From: Laura Gibbons
Sent: 07 August 2018 15:05
To: 'Brad Wiseman'
Cc: Juan Baeza; Anita Gardner
Subject: FW: Planning Application: FG/105/18/PL - Asda, Littlehampton Road, Ferring Worthing.
Importance: High

From: Paul Gill [REDACTED]
Sent: 18 July 2018 12:30
To: Laura Gibbons
Cc: Andy Clifton; Brad Wiseman; Chris Hill; Richard Sanderson; Tony Murray; Adam Slade
Subject: Planning Application: FG/105/18/PL - Asda, Littlehampton Road, Ferring Worthing.
Importance: High

Title
Tank Farm general
arrangement

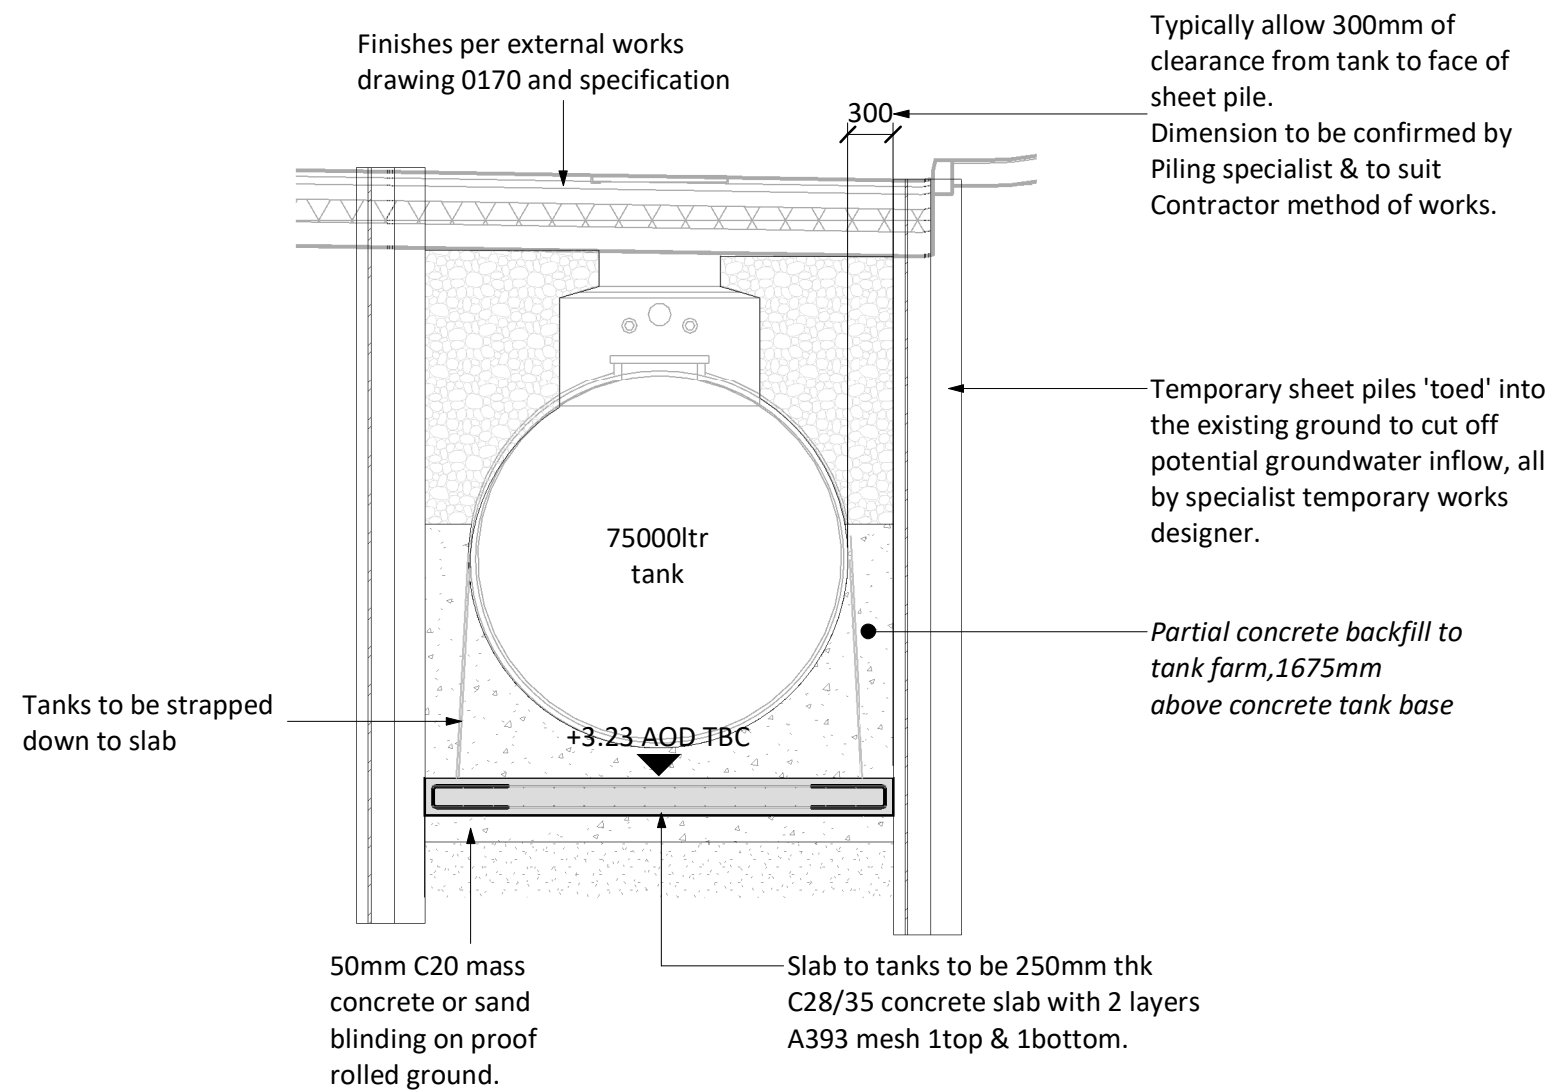
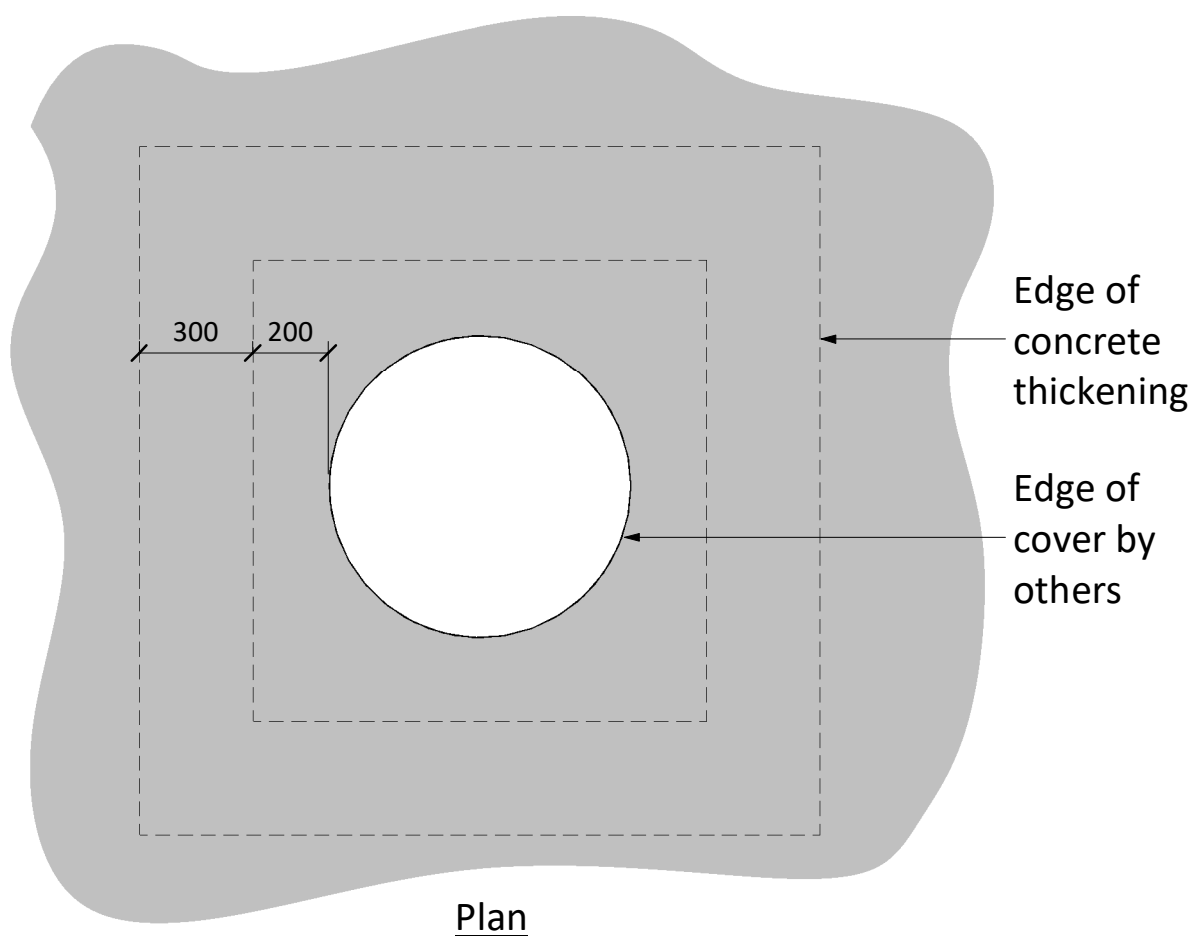
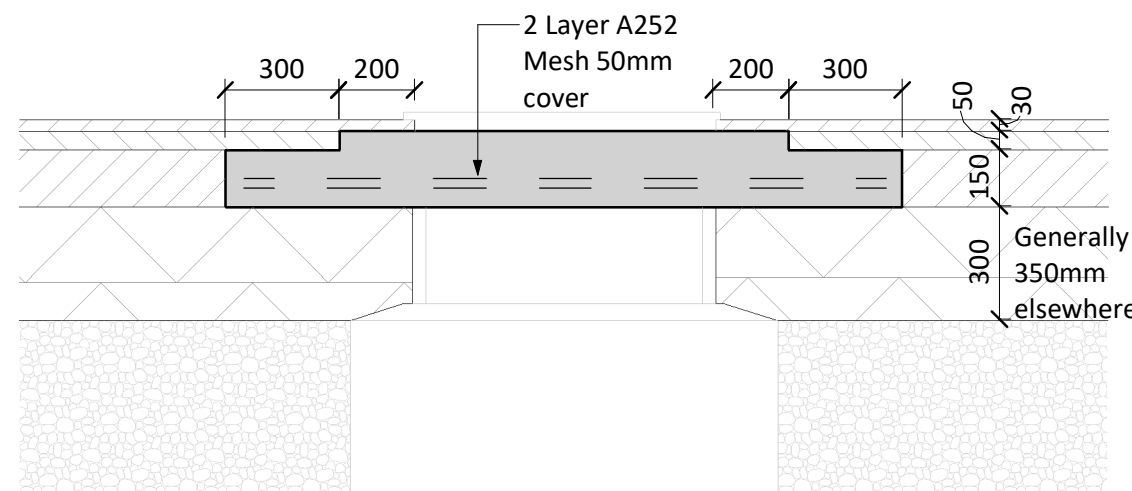
- Confirmation of the rating of the existing hydrobrake. I will require proof that the existing hydrobrake is rated at 2l/s. This could be contained within the maintenance manual, or a copy of the delivery note may be available, or details may be held in the health and safety file.
- I will also require calculations showing that the network which is already served by the hydrobrake is not surcharged to the extent that flooding occurs as a result of the new proposals.
- The original calculations I was supplied with were presuming the hydrobrake was 5l/s. Please provide revised calcs for 2l/s that show that the proposed Alderburgh tank is sufficient to hold the 1 in 100 year event plus 30% climate change.

I would like to see calculations showing the new proposed system and the as built system. As the hydro brake is already being used it is currently unclear if there is sufficient capacity for both systems to work together.

I will require further construction detail drawings showing the attenuation tank, hydrobrake, pipe protection details, manholes and catchpits. I will also require calculations proving the design meets our requirements in terms of storage and half drain time.

The micro drainage calculations indicate that to avoid flooding an equivalent area of Alderburgh tank needs to be $310\text{m}^2 \times 0.55\text{m deep} = 170.5\text{m}^3 \times 0.95 \text{ (void ratio)} = 162\text{m}^3$. This volume is less than the 191.4m^3 that has been provided.

1. Construction details of the tank are shown on our drawing 102 Rev P1 – Attached. This will be a sealed system and now allowed to soakaway.
2. Hydrobrake – The Hydrobrake is existing in manhole EX01, we are not proposing for this manhole to change. Rating is 5 l/s.
3. Pipe protection details – Drawing 102 Rev P1 shown examples of concrete encasement for pipe protection.
4. Typical manhole detail is shown on drawing 102 Rev P1.
5. I attach micro drainage calculations for the attenuation proposed on site at discharge rate of 5 l/s.
